Application Ref: 21/00290/ADV

<p><b>UPRN:</b> 000120036115 _____ (If <b>NO</b> UPRN – Admin to contact Technician)</p> <p><b>Site Address:</b> <i>(Leave blank if no UPRN)</i></p> <p>Land South West of Tesco Superstore Dalkeith</p>	<p><b>Description of Proposal:</b></p> <p>Display of illuminated and non-illuminated signage including fascia, totem and free standing signs</p>
---	--

**APPLICATION INCOMPLETE**

PROPOSED FRONT ELEVATION (1:50)

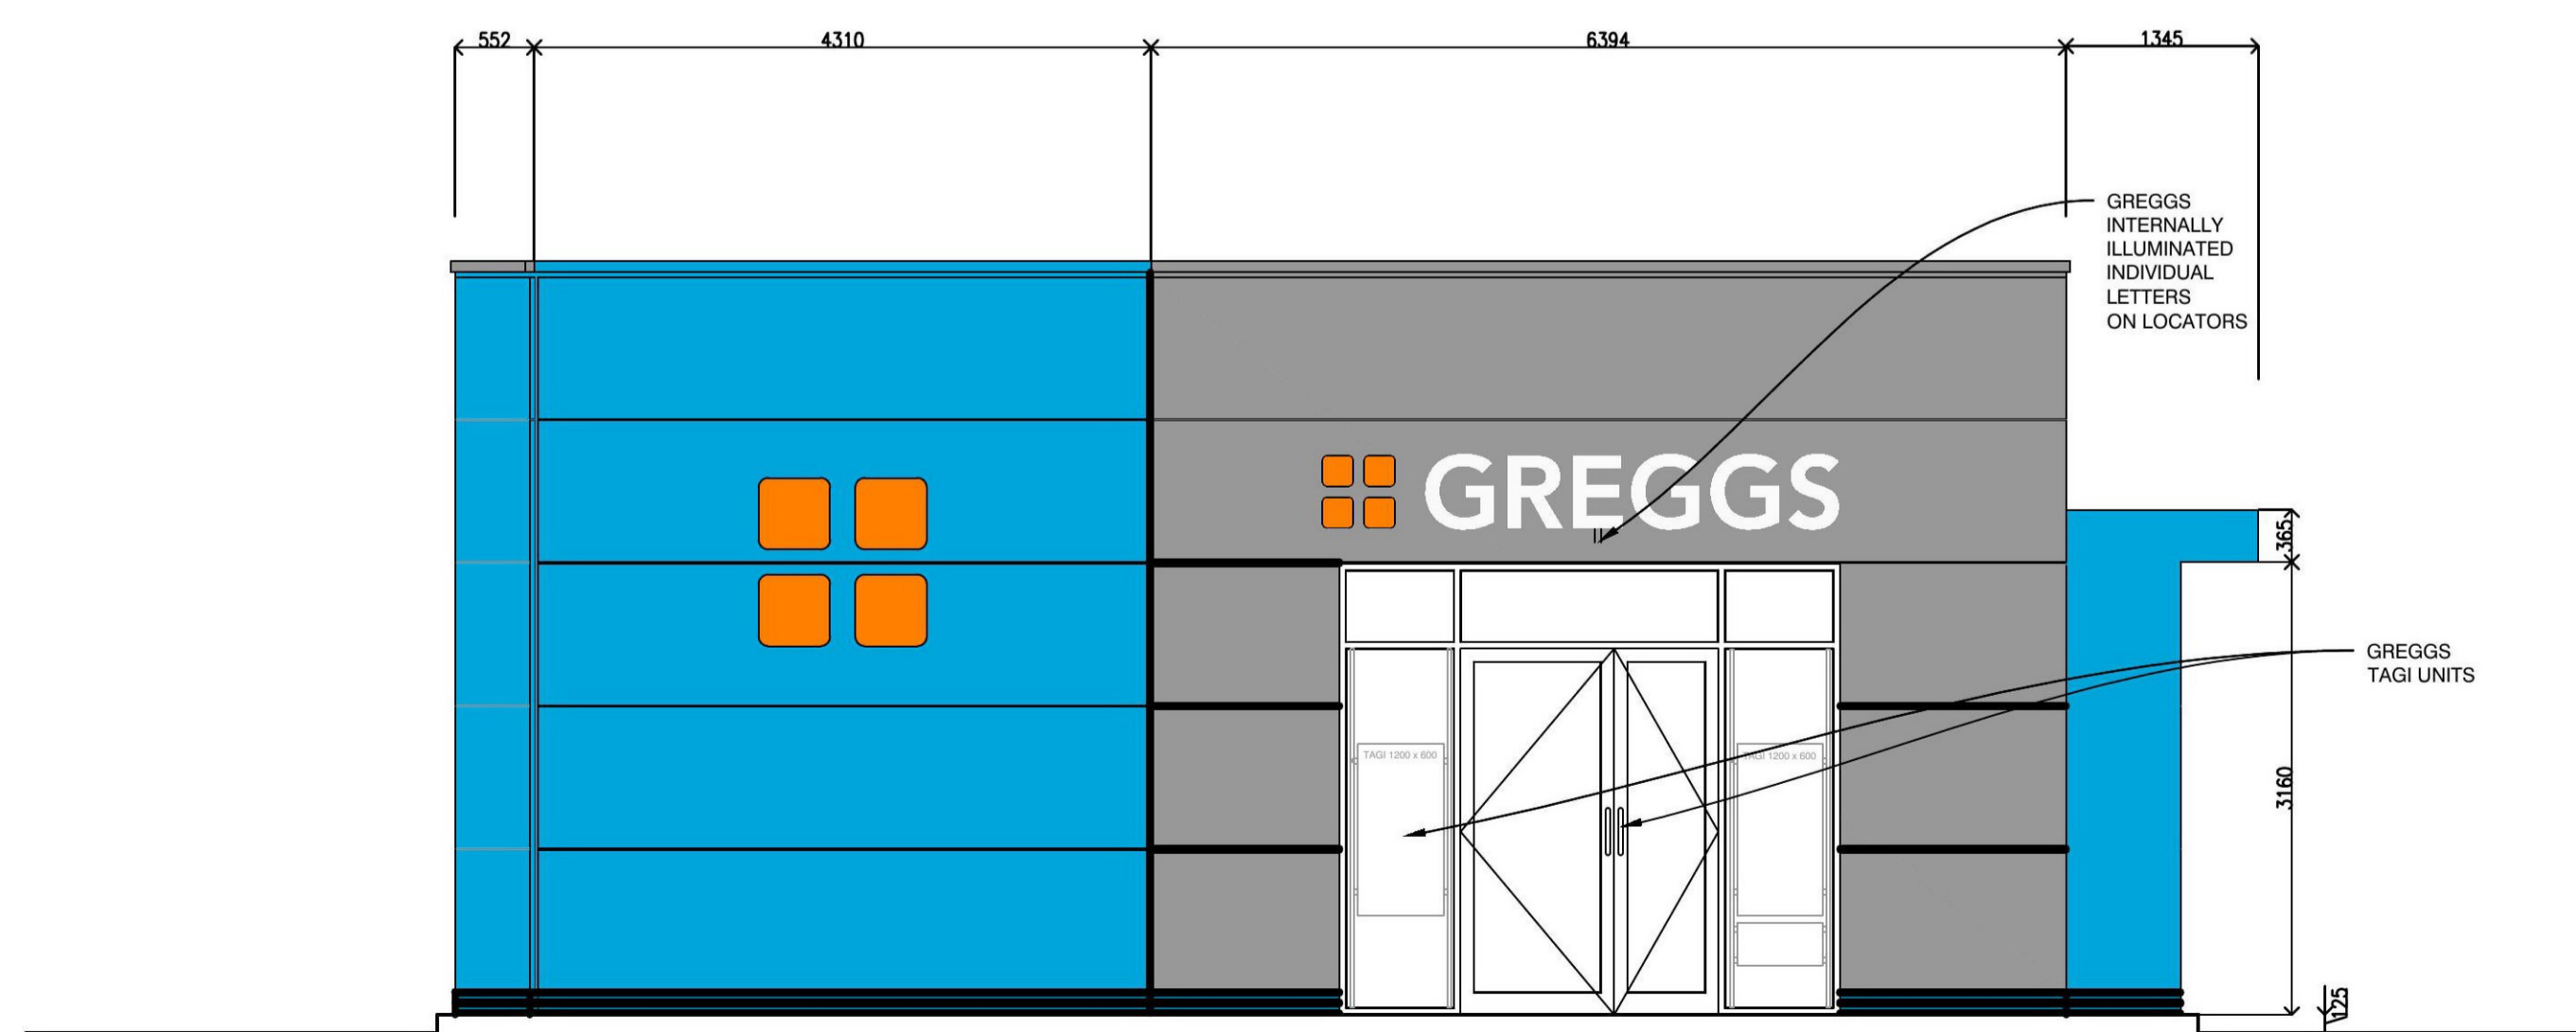
On drawing no. RNTH/S5554/02-3 the proposed totem sign is not labelled as sign 8.

On drawing no. RNTH/S5554/02-3 there is no indication of whether the signs are illuminated or non-illuminated.
